DEPARTMENT OF PARKS AND COMMUNITY SERVICES

March 27, 2024

Subject: Bull Hill and Rolling Meadows Sketch Plan (SKP-23-003)

**SKP02**  
SHEET 02 OF 03

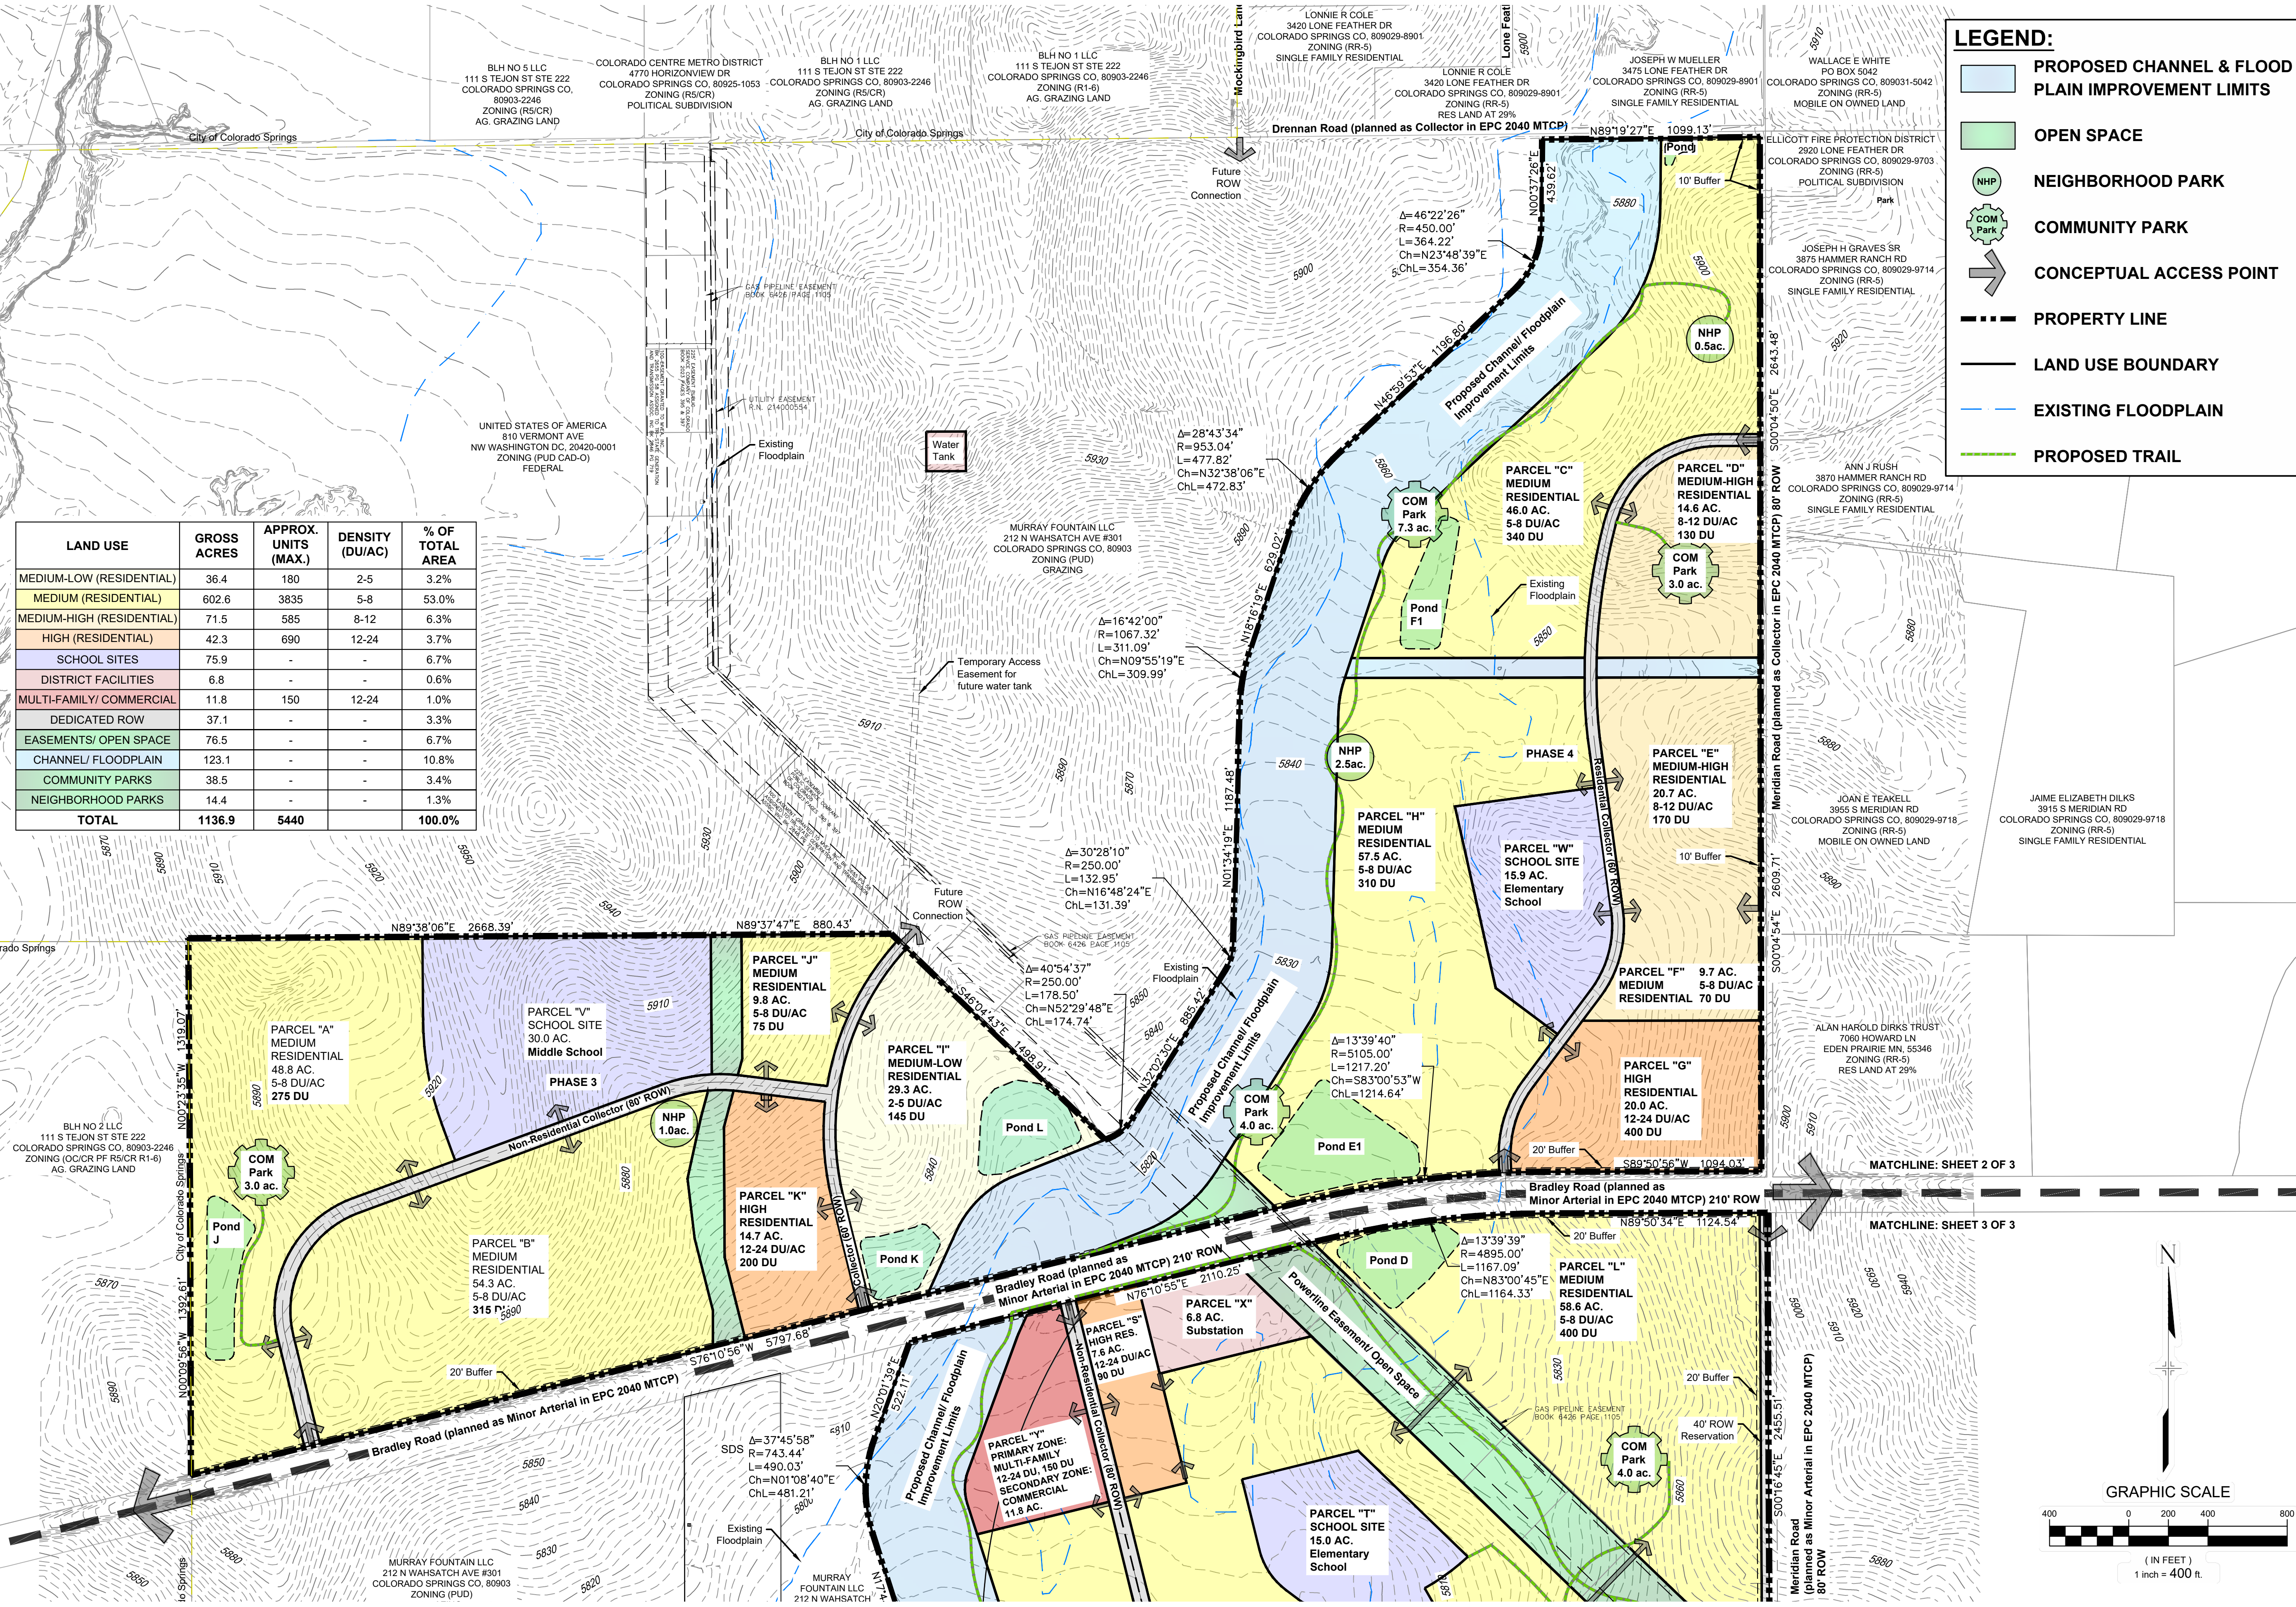
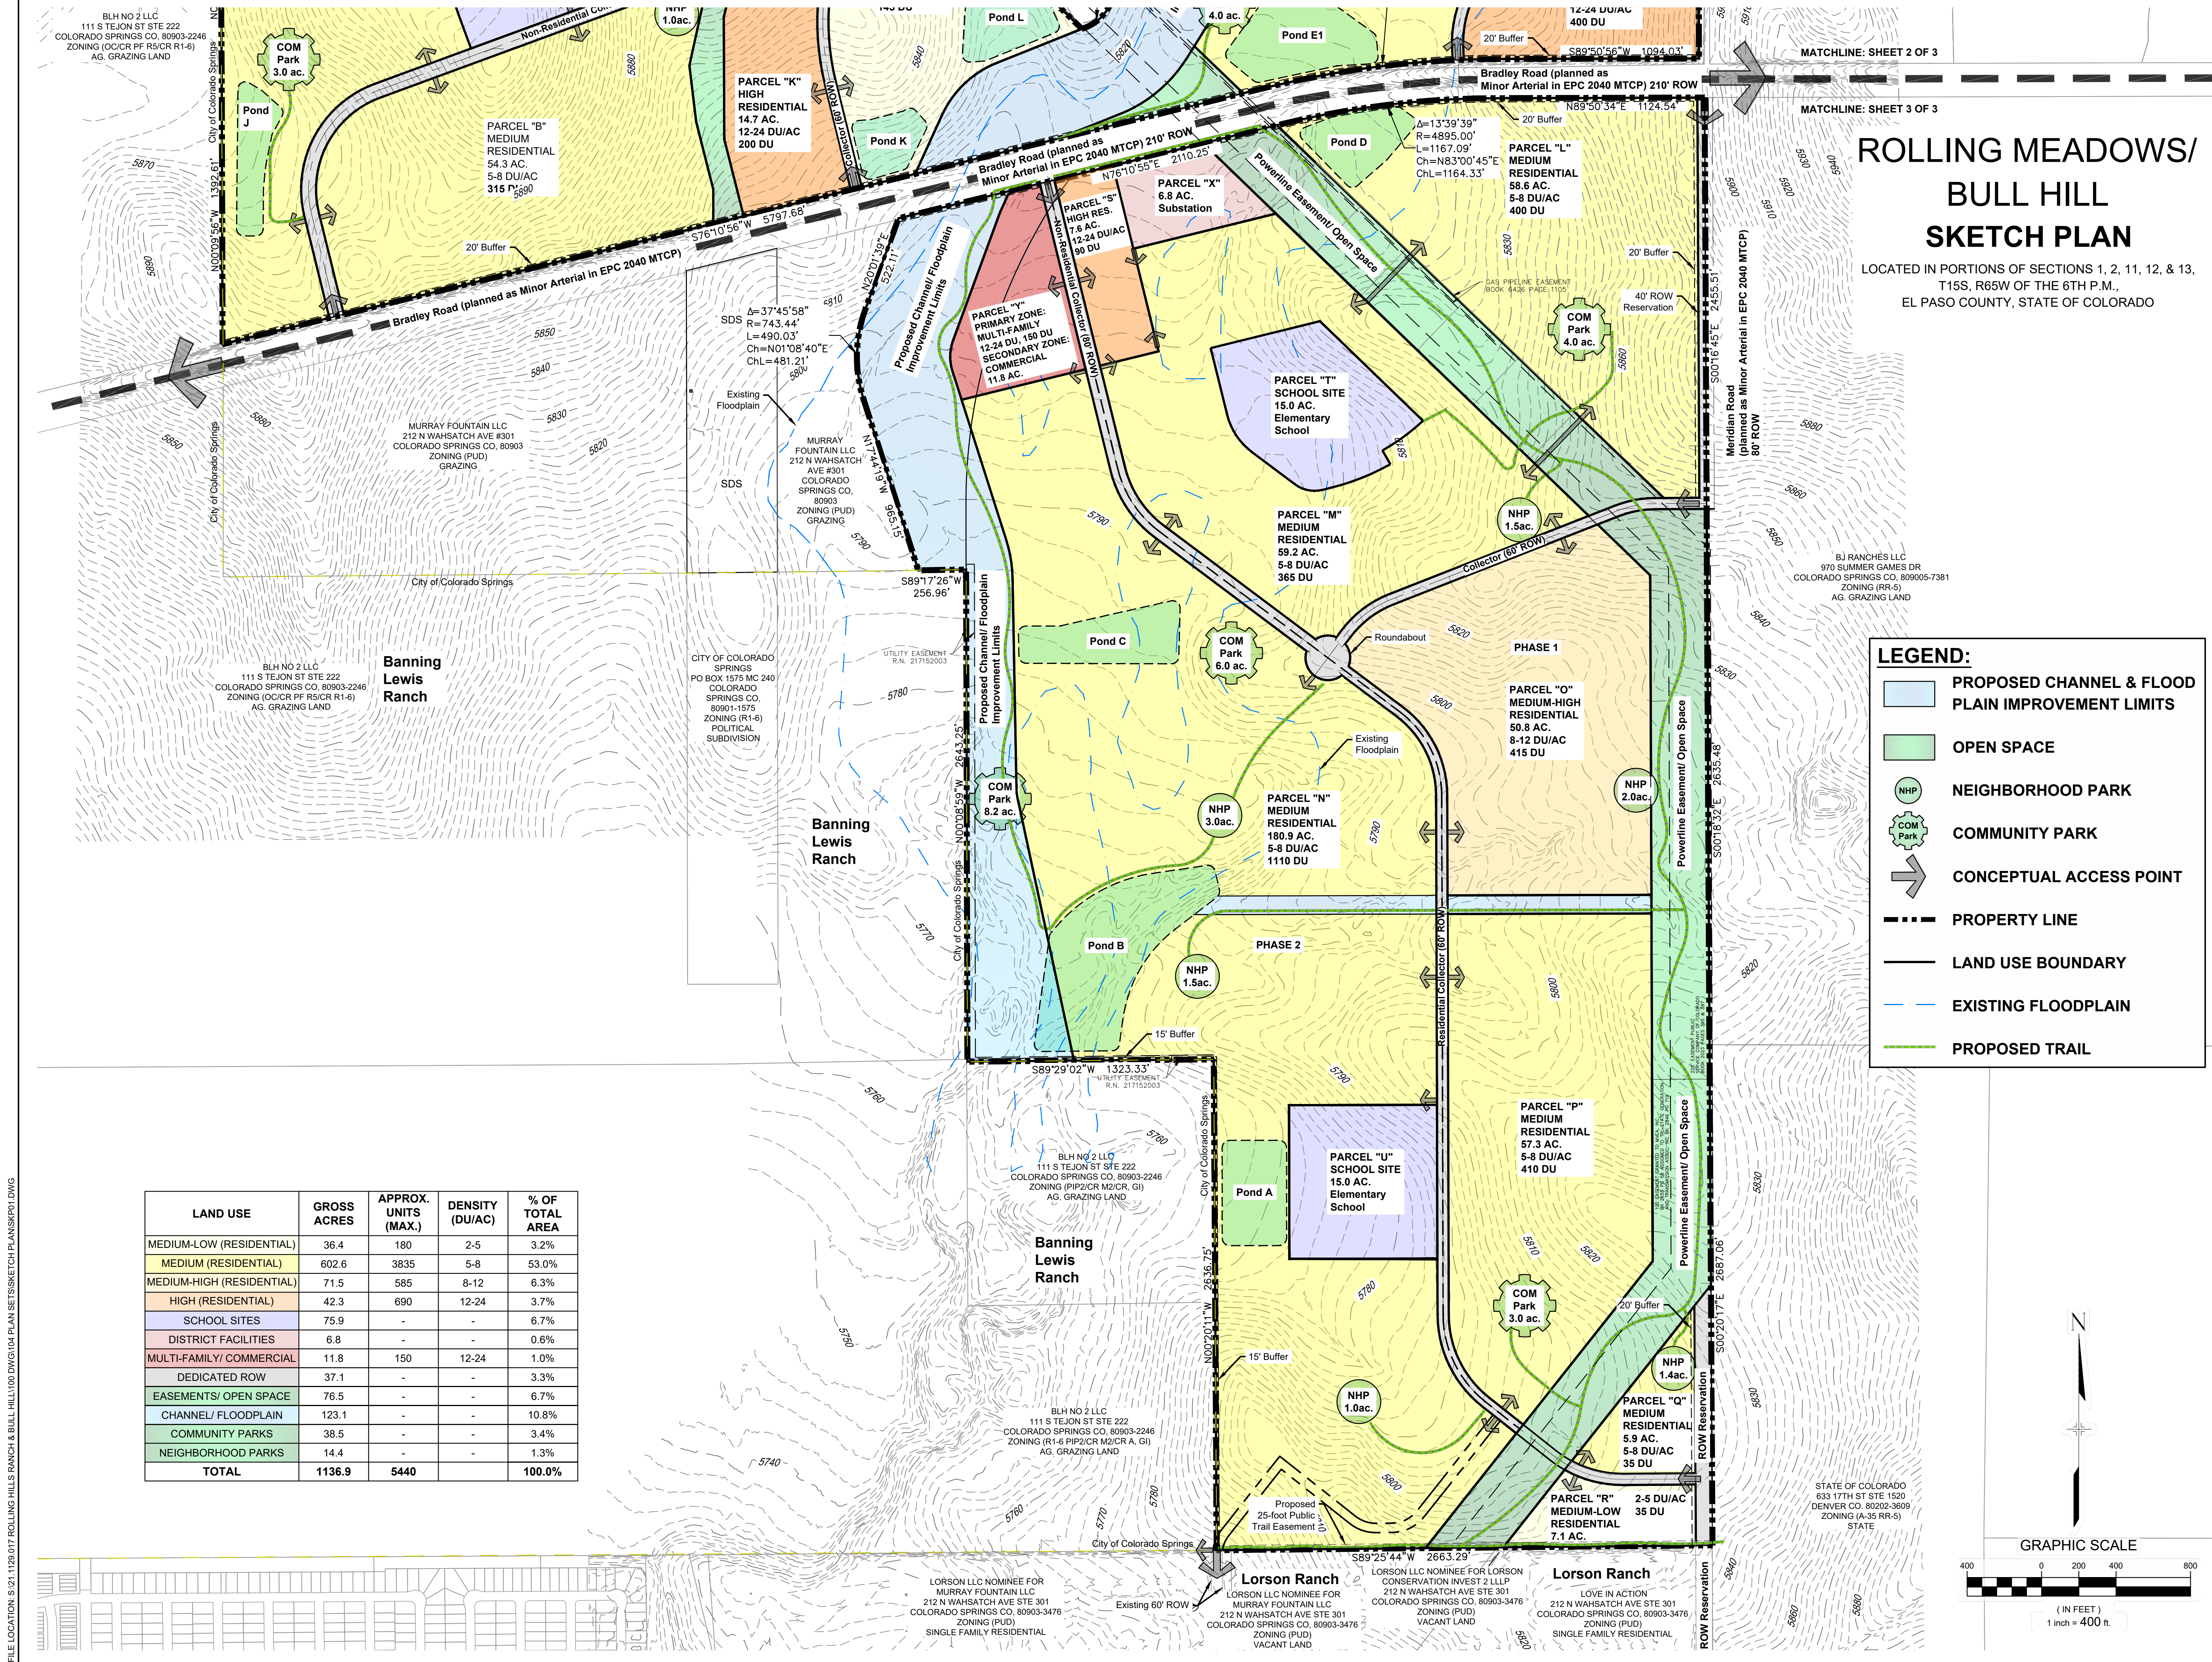
a 25-foot public trail easement along the southern boundary of Bull Hill and Rolling Meadows for the purpose of construction and maintenance of the Jimmy Camp Creek Primary Regional Trail. Lastly, staff recommends regional and urban park fees in lieu of land dedication on all forthcoming Final Plats.

“The Park Advisory Board recommends that the Planning Commission and the Board of County Commissioners include the following conditions when considering and/or approving the Bull Hill and Rolling Meadows Sketch Plan: (1) designate and provide to El Paso County a 25-foot public trail easement along the southern boundary of Bull Hill and Rolling Meadows, that allows for public access, as well as construction and maintenance by El Paso County of the Jimmy Camp Creek Primary Regional Trail; (3) the trail easement shall be shown on all forthcoming Preliminary Plans and Final Plat(s), and the aforementioned easement shall be dedicated to El Paso County on the forthcoming Final Plat(s); (4) fees in lieu of land dedication for regional and urban park purposes will be calculated upon review of forthcoming Preliminary Plans and Final Plats, and will be required at time of the recording of the forthcoming Final Plats. Park Lands Agreements may be acceptable alternatives to urban park fees provided the agreements are approved by the County and executed prior to recording the forthcoming Final Plat(s).”
